County File No. PPR2048

DRAWN BY: D.E. WATTS DATE: 12-4-20 DWG. NO.: 20-5449-04 PERFORMED BY: COUNTY LICENSE SURVEYED BY: DEV. ESW. 4-29-20 12-4-20	APPROVED BY: PROJ. NO.: DWG.	REVISIONS 7-6-21 REVISED PER COUNTY REVIEW DEW 1-26-22 REVISED PER COUNTY REVIEW DEW	OLIVER E. WATTS CONSULTING ENGINEER COLORADO SPRINGS	PROJECT 16965 LINDBERGH ROAD N1/2, N1/2, NW1/4, SE1/4, SEC. 22, T.11S., R.67W. EL PASO COUNTY	SHEET NAME GRADING AND EROSION CONTROL PLAN	SHEET NO. OF 2
---	------------------------------------	---	--	--	---	-------------------

DRAINAGE SWALE DETAIL
N.T.S.

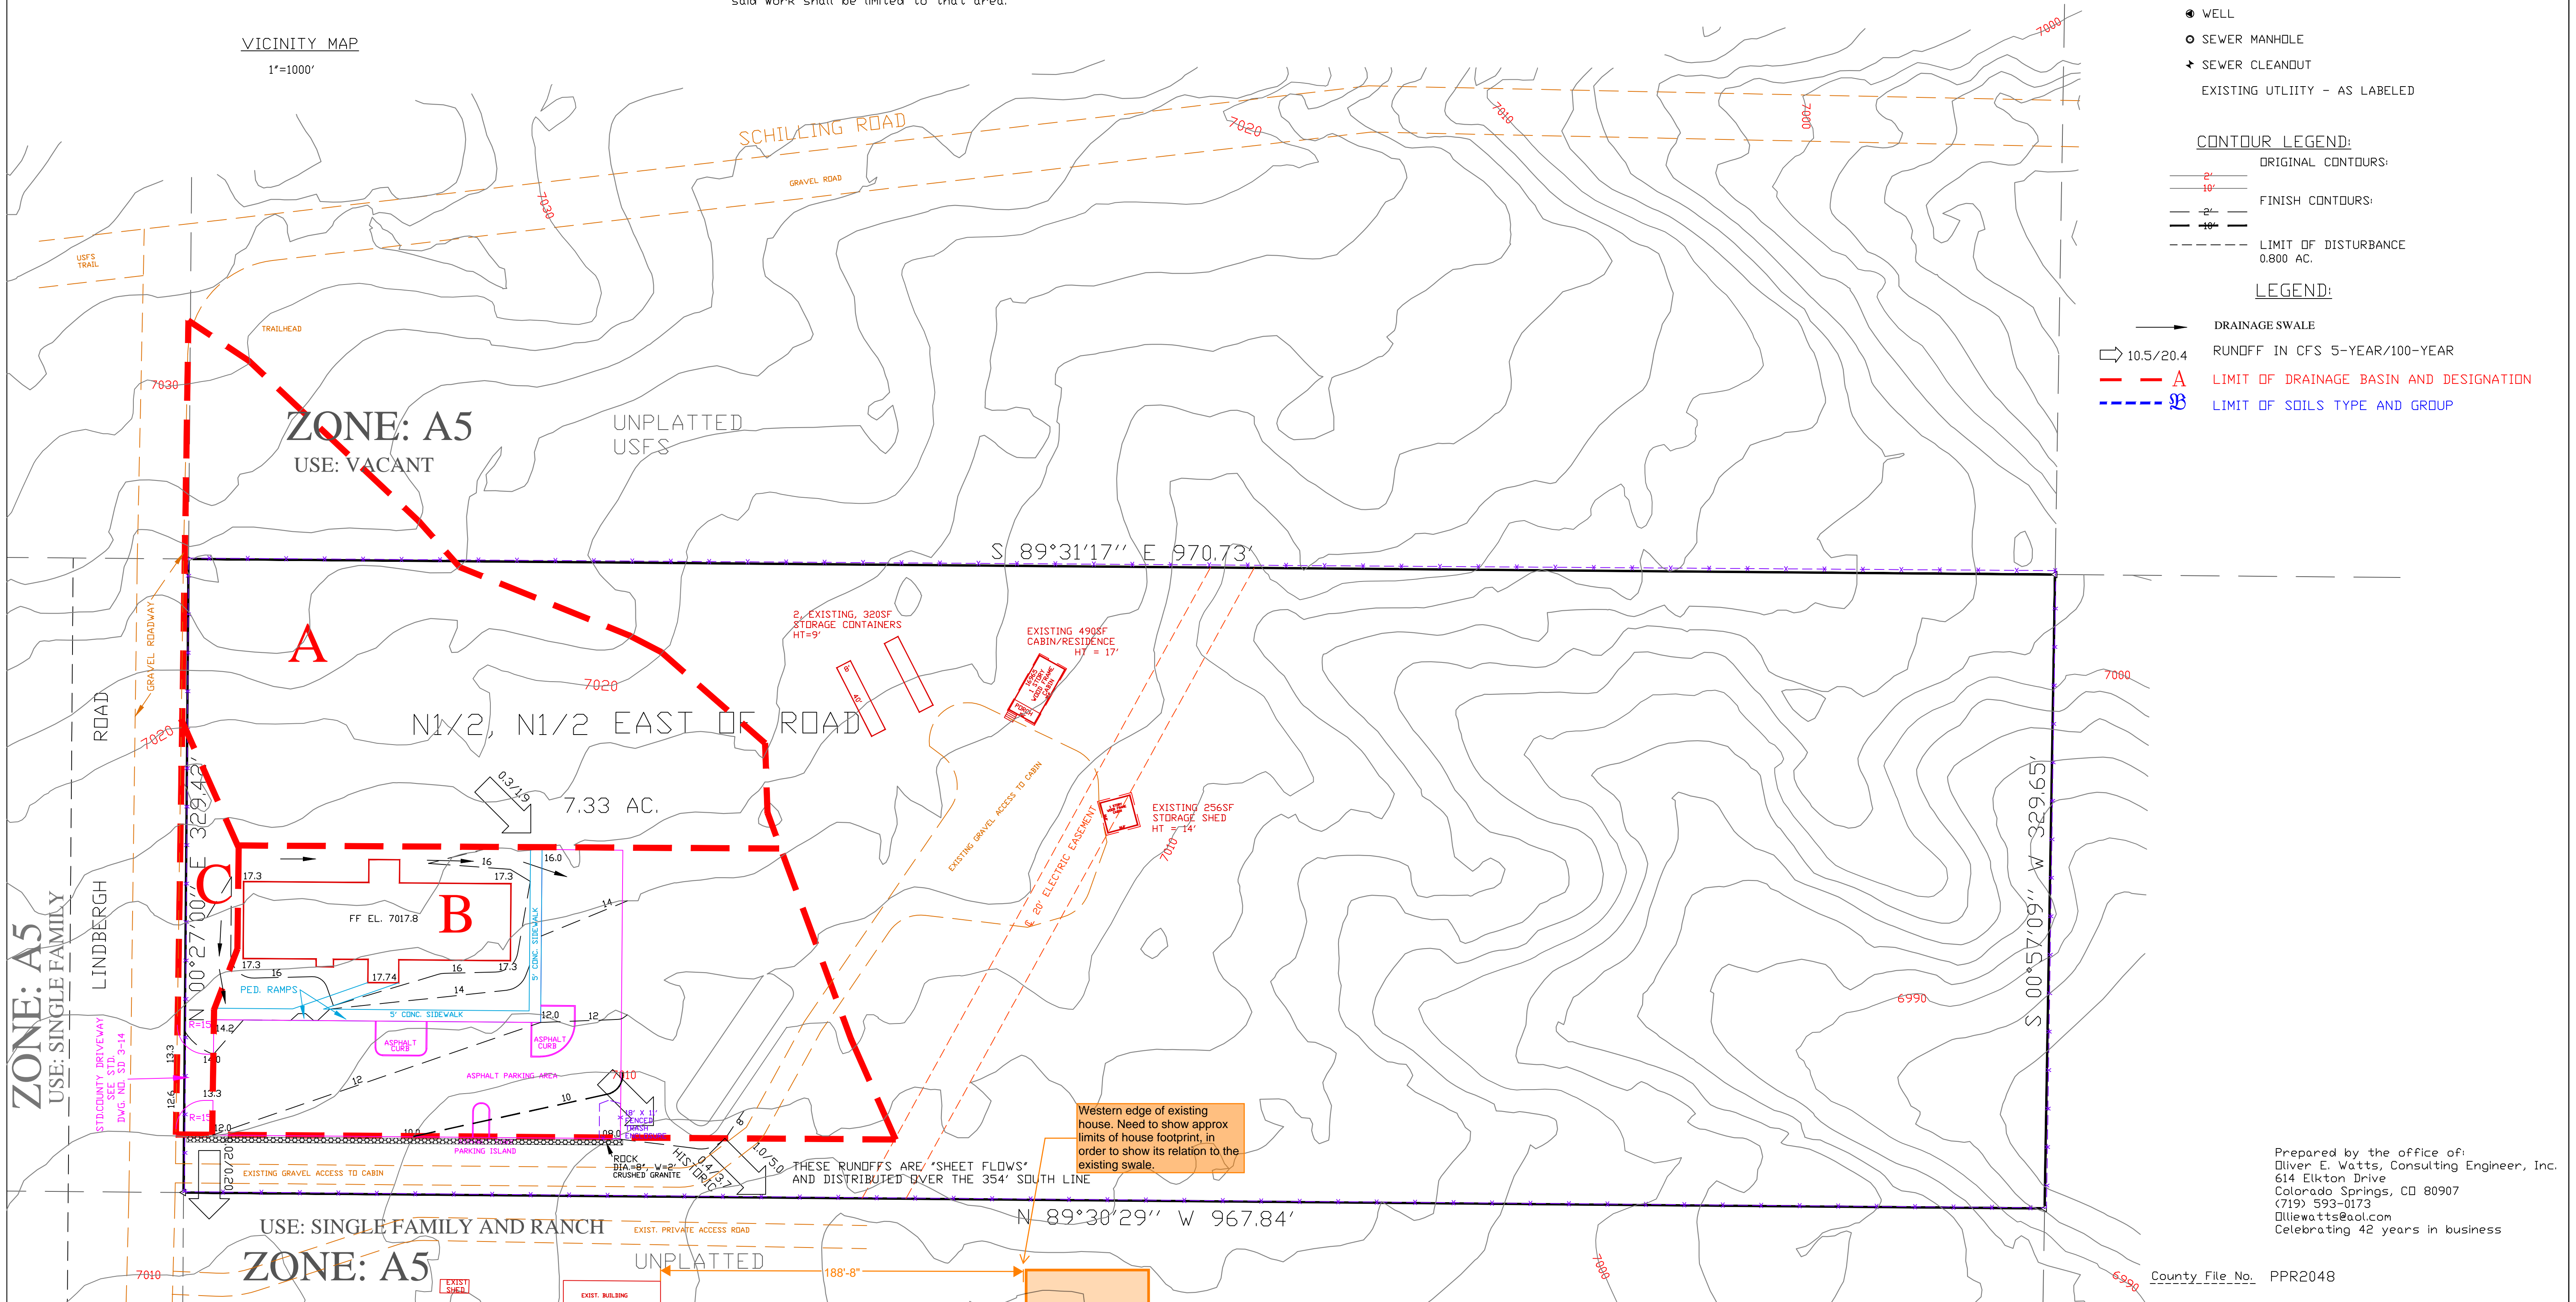
Unresolved comment from Review #1 & 2:
1) We have concerns about the feasibility of constructing asphalt abutting to limits of disturbance. Will there be fencing around limits of disturbance to prevent asphalt machinery from exceeding limits, for example? Please add a note to this plan describing how what measures will be taken to contain the limits of disturbance.

Review #3 update: Item "N" in the GEC Checklist states: "Identify and protect areas outside of the construction site boundary with existing fencing, construction fencing or other methods as appropriate." We would like to see some form of fencing to ensure the LOD remains <1ac.

Combined area of disturbance is >1ac. So an ESQCP and a PBMP would be necessary along with all of their accompanying documents, unless total disturbed area is reduced back to <1ac.

As the area of disturbance is greater than 1 acre, please update the FAE (use current 2022 form on County website).

provide some form of permanent outlet protection here to prevent against soil erosion from concentrated flows.

Unresolved comment from Review #1 & #2:
For clarity, please show approximate location of neighbor's driveway and their existing barn and house.

Review #3 update: Item F on the GEC Checklists requires all existing structures be shown on the GEC Plan. And to properly determine suitability of the outfall location, we need to see where the adjacent structures are to verify that drainage is being directed away from those structures.
